Re: Serenity Trails Subdivision – PA24-001 – Technical Review 2
3209 83rd Ave NE – APN(s) 00590700028500

RE: Serenity Trails Subdivision, File# PA24-001 TR2

SUBJECT: PA24-001 Serenity Trails Subdivision
3208 83rd Ave NE
APN's: 00590700028500

SUBJECT: PA 24-001 – Serenity Trails

**PRELIMINARY PLAT MAP**

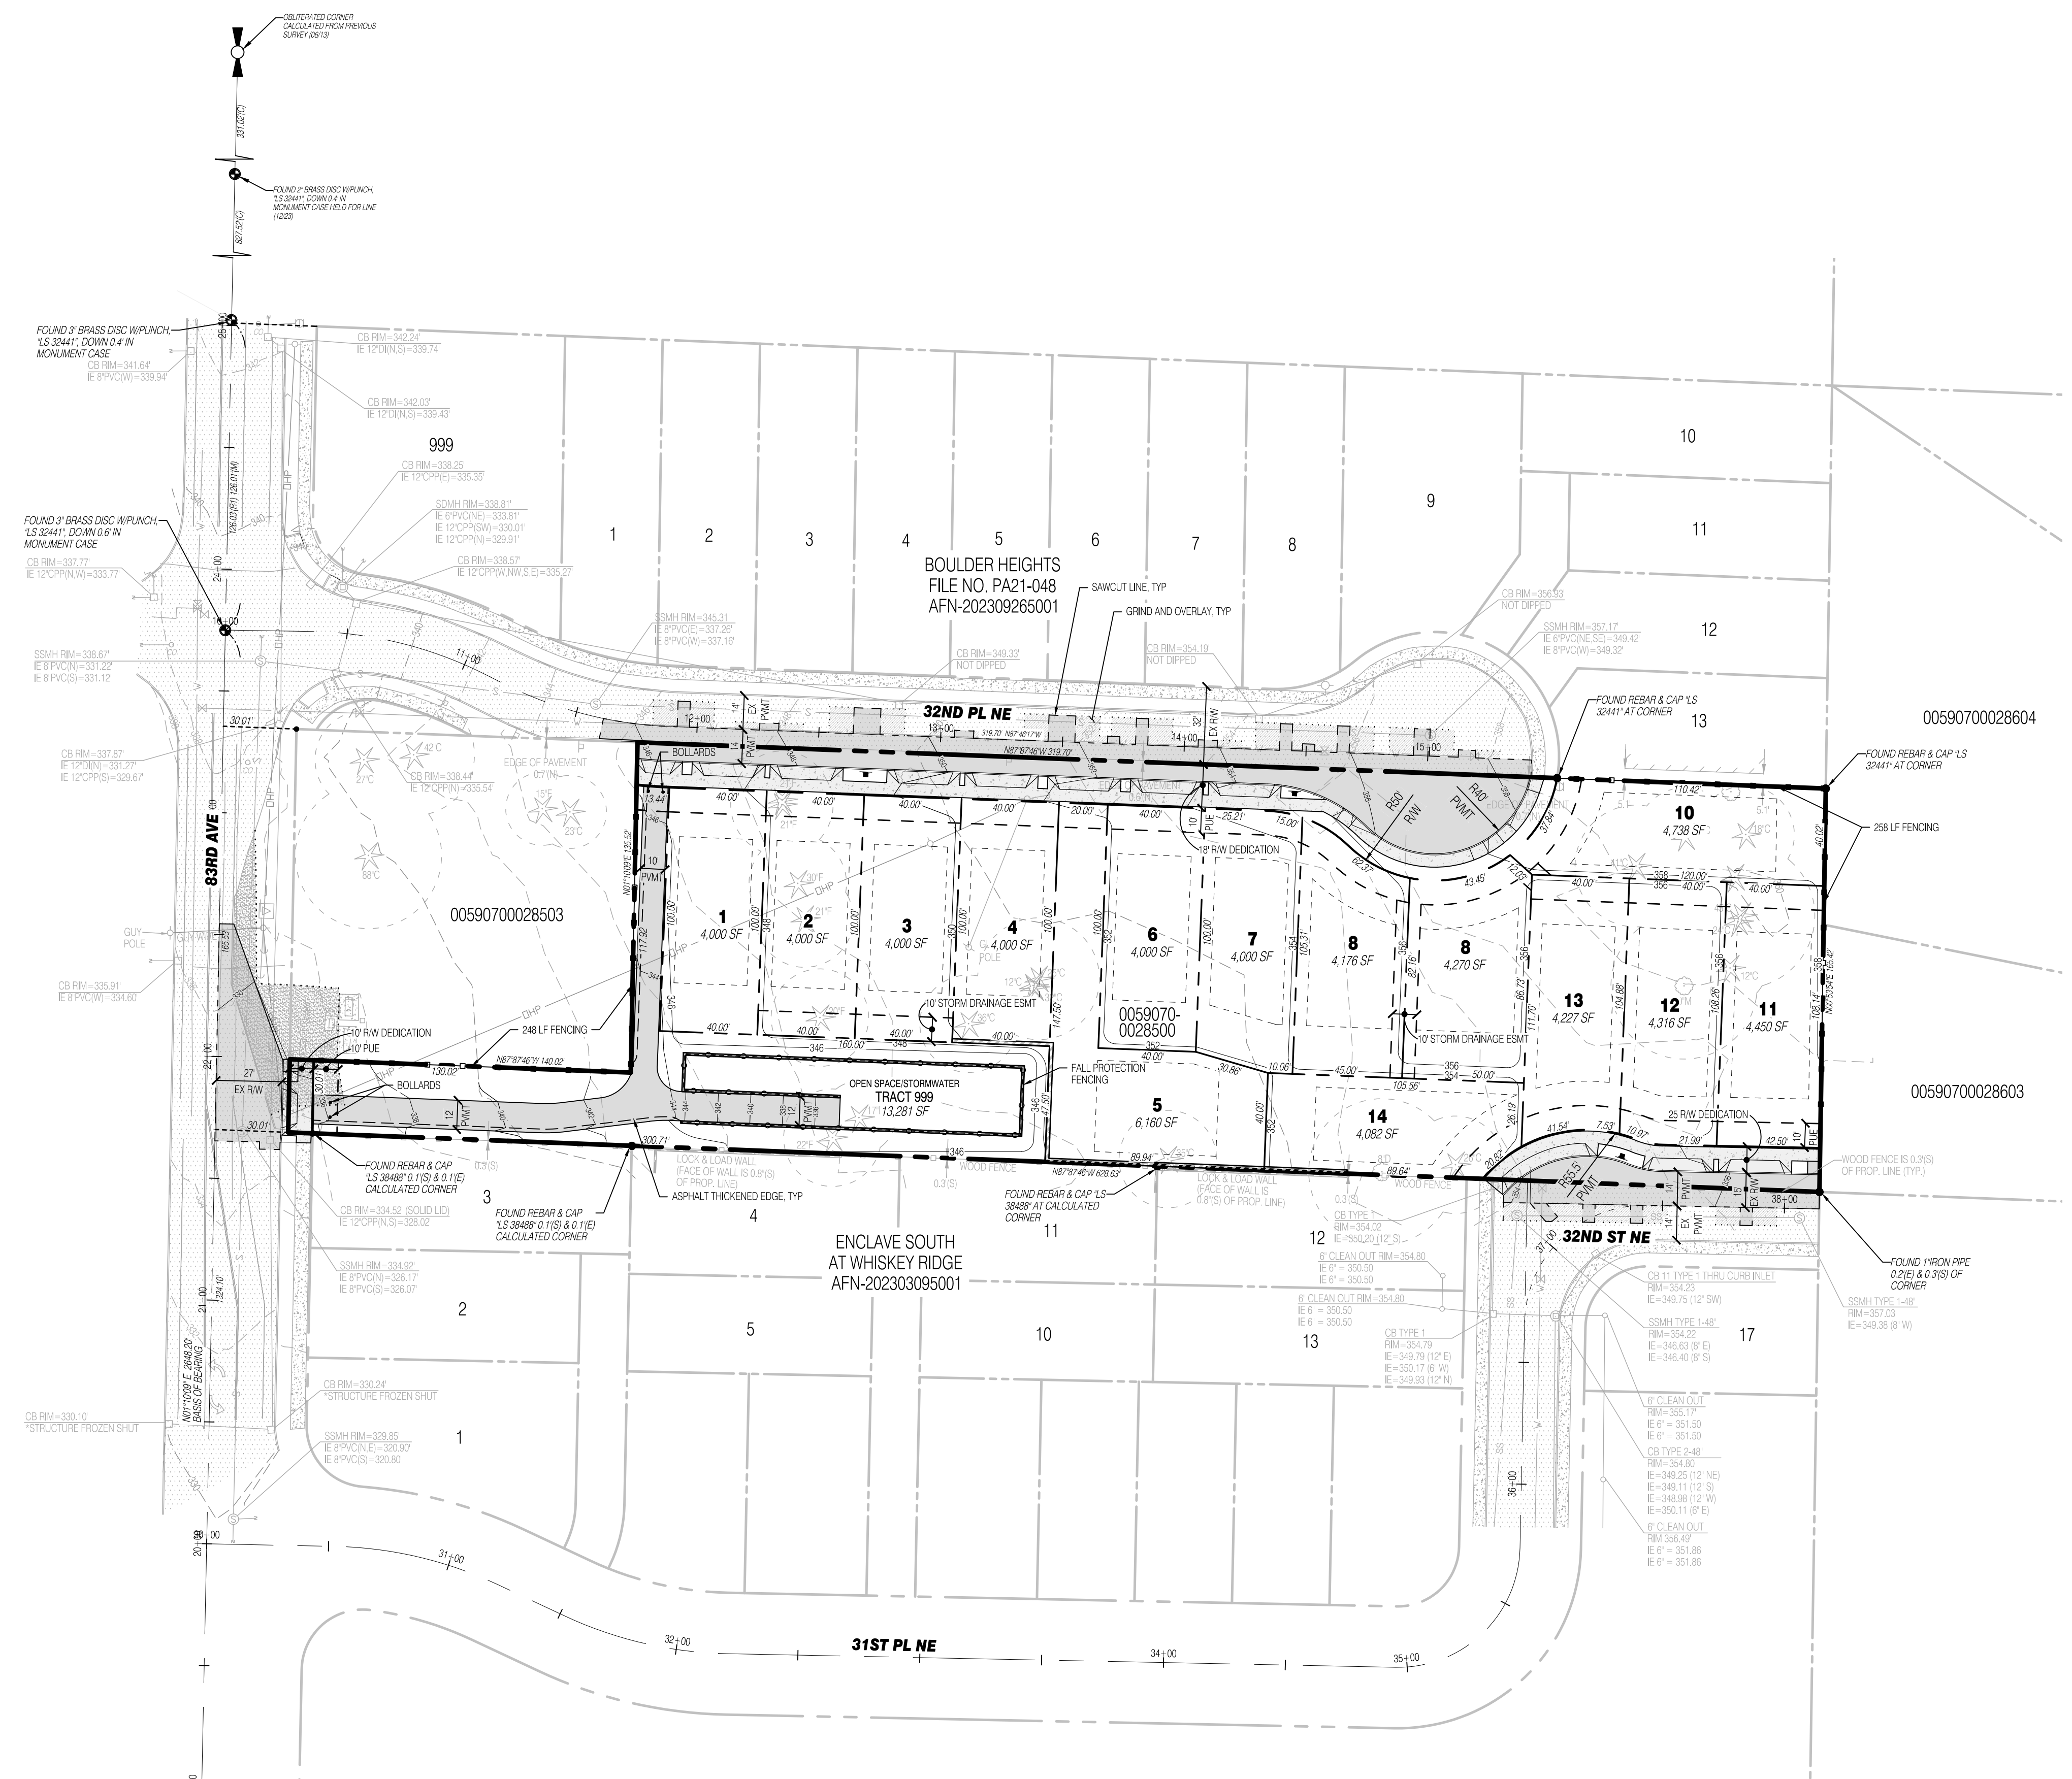
1. **Access:**
 - a. Elbow intersections per SP 3-209-002 are allowable on local access streets only and are subject to intersection spacing requirements established under section 3-209 of the EDDS. Please provide a zoomed in detail for the proposed elbow on 32nd ST NE showing the turning movement.
 - b. Please show how lot 14 will take access off of 32nd ST NE.

PP-01
3 OF 8

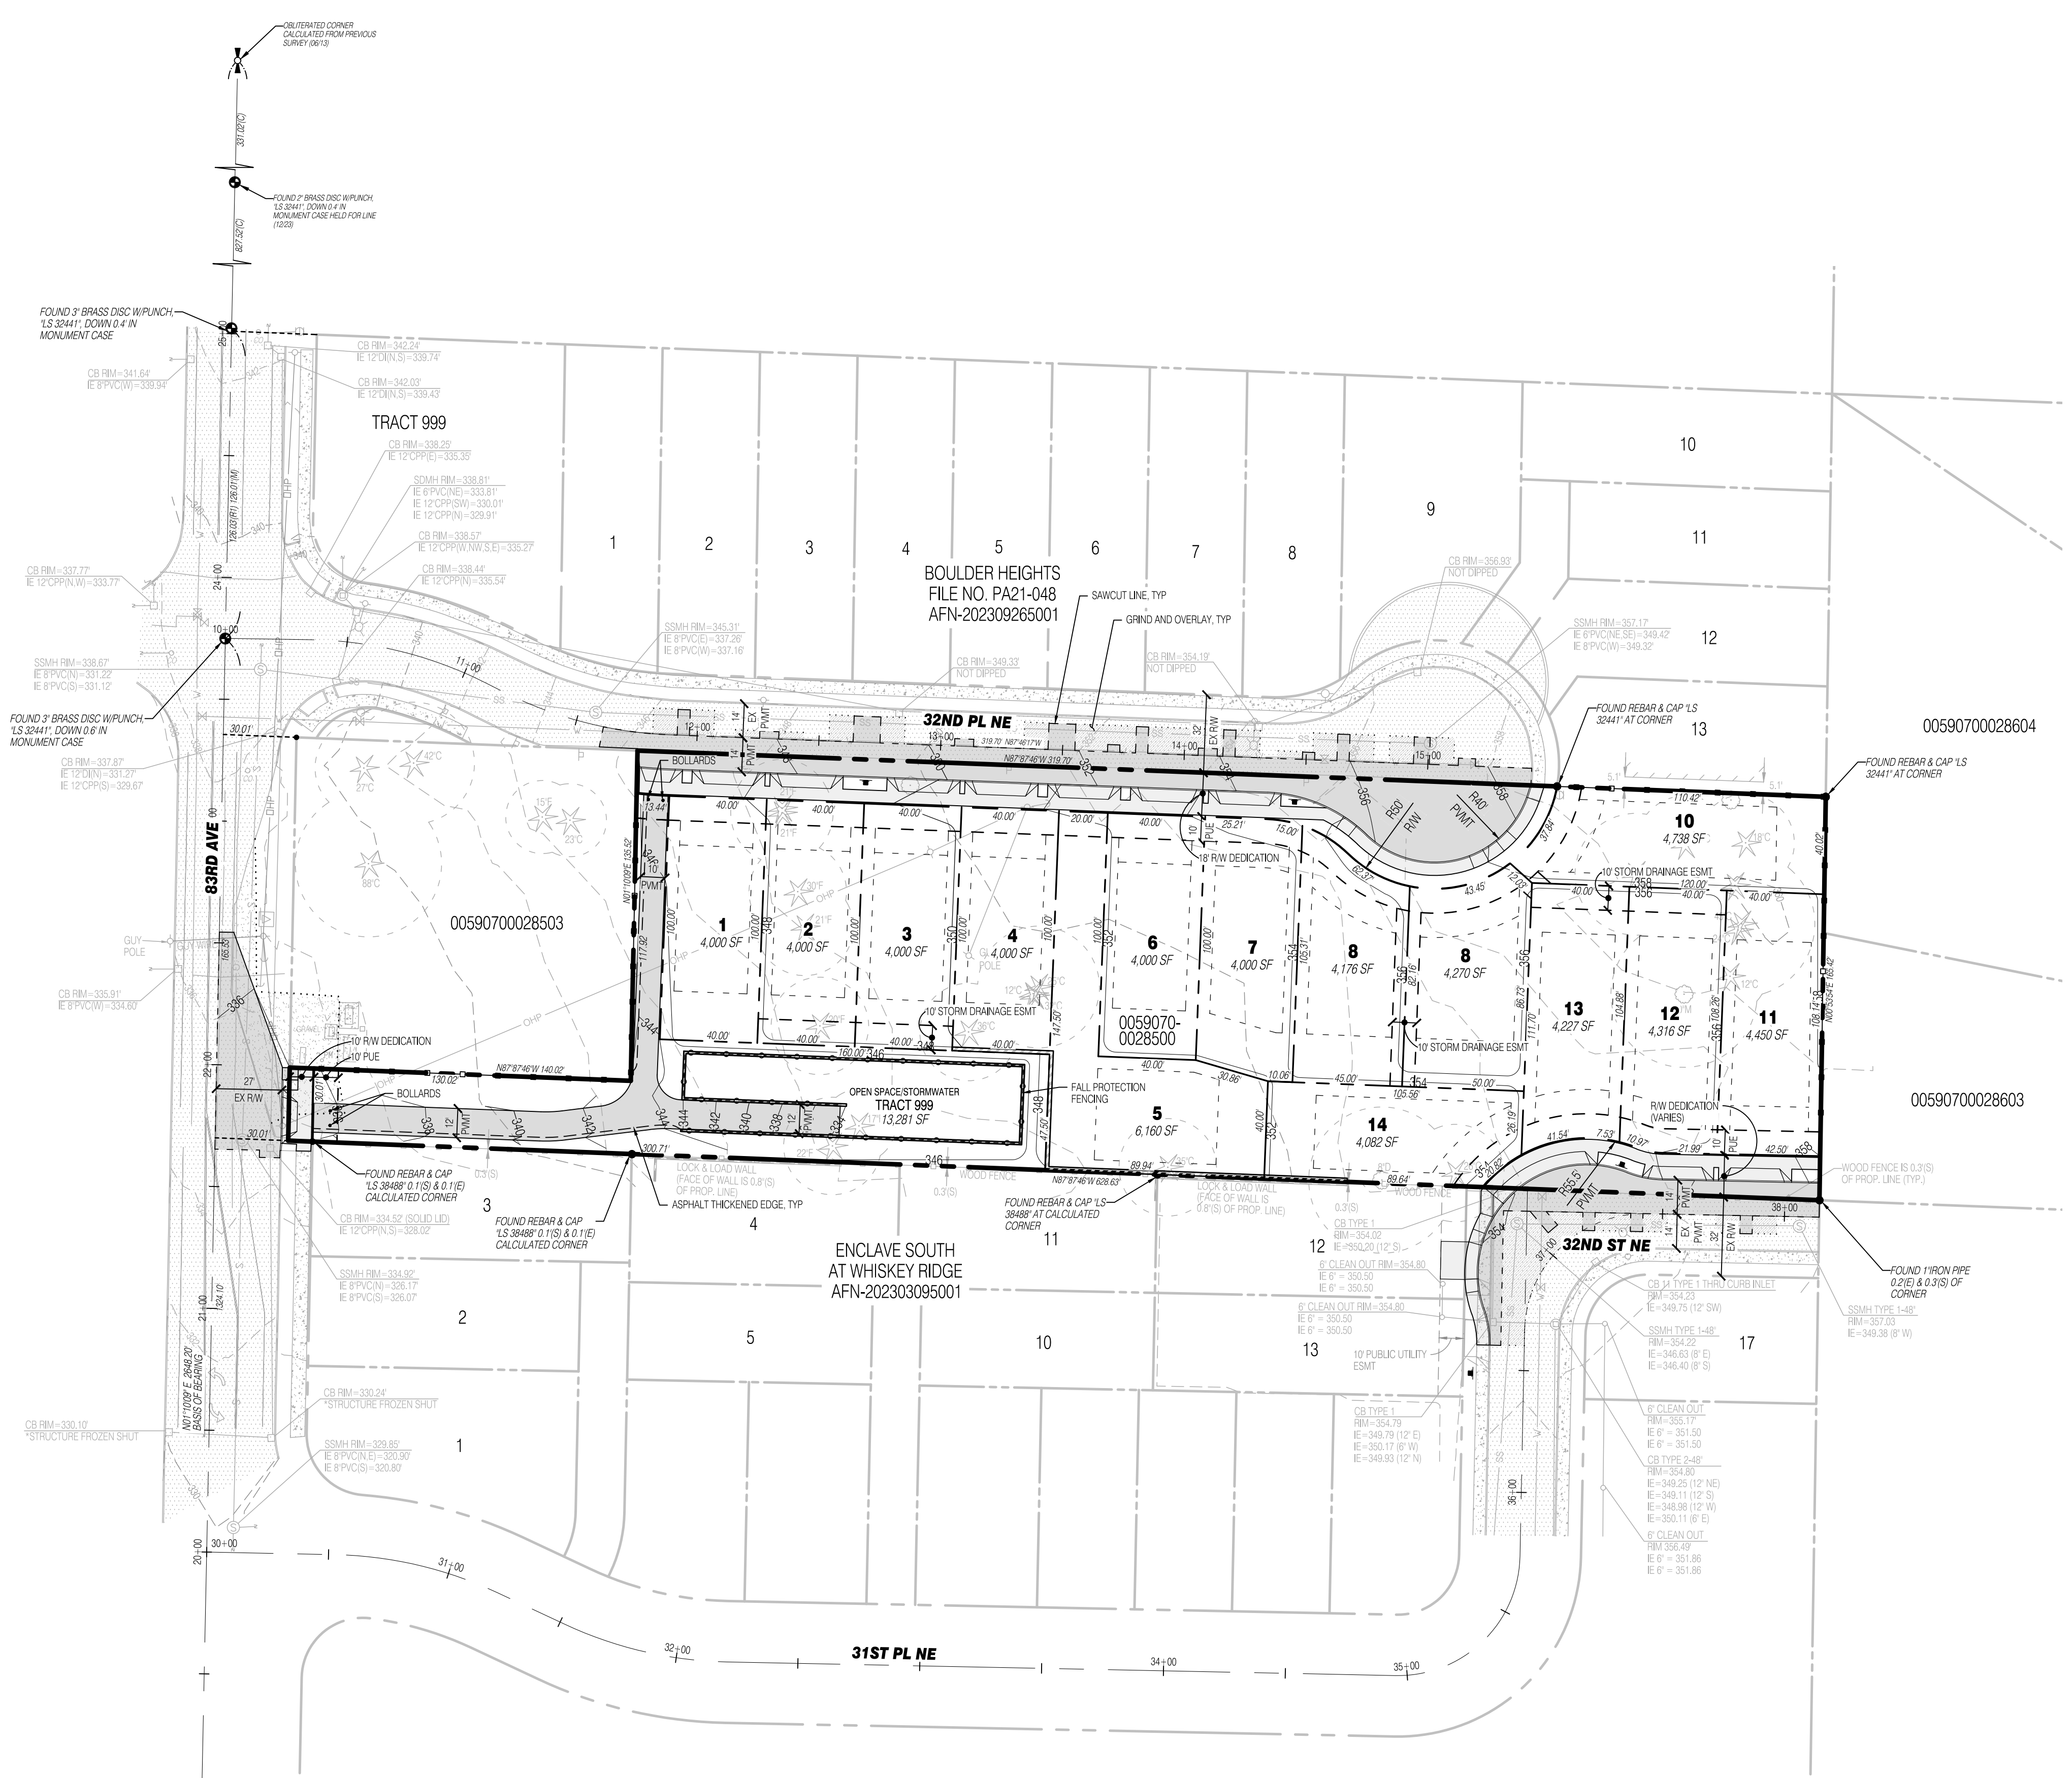
- a. TIA is acceptable.
- 3) Undergrounding of existing overhead utilities along frontage of 83rd Ave NE shall be required.
- 4) Per EDDS 3-506, street lighting will be required as part of civil construction plans.
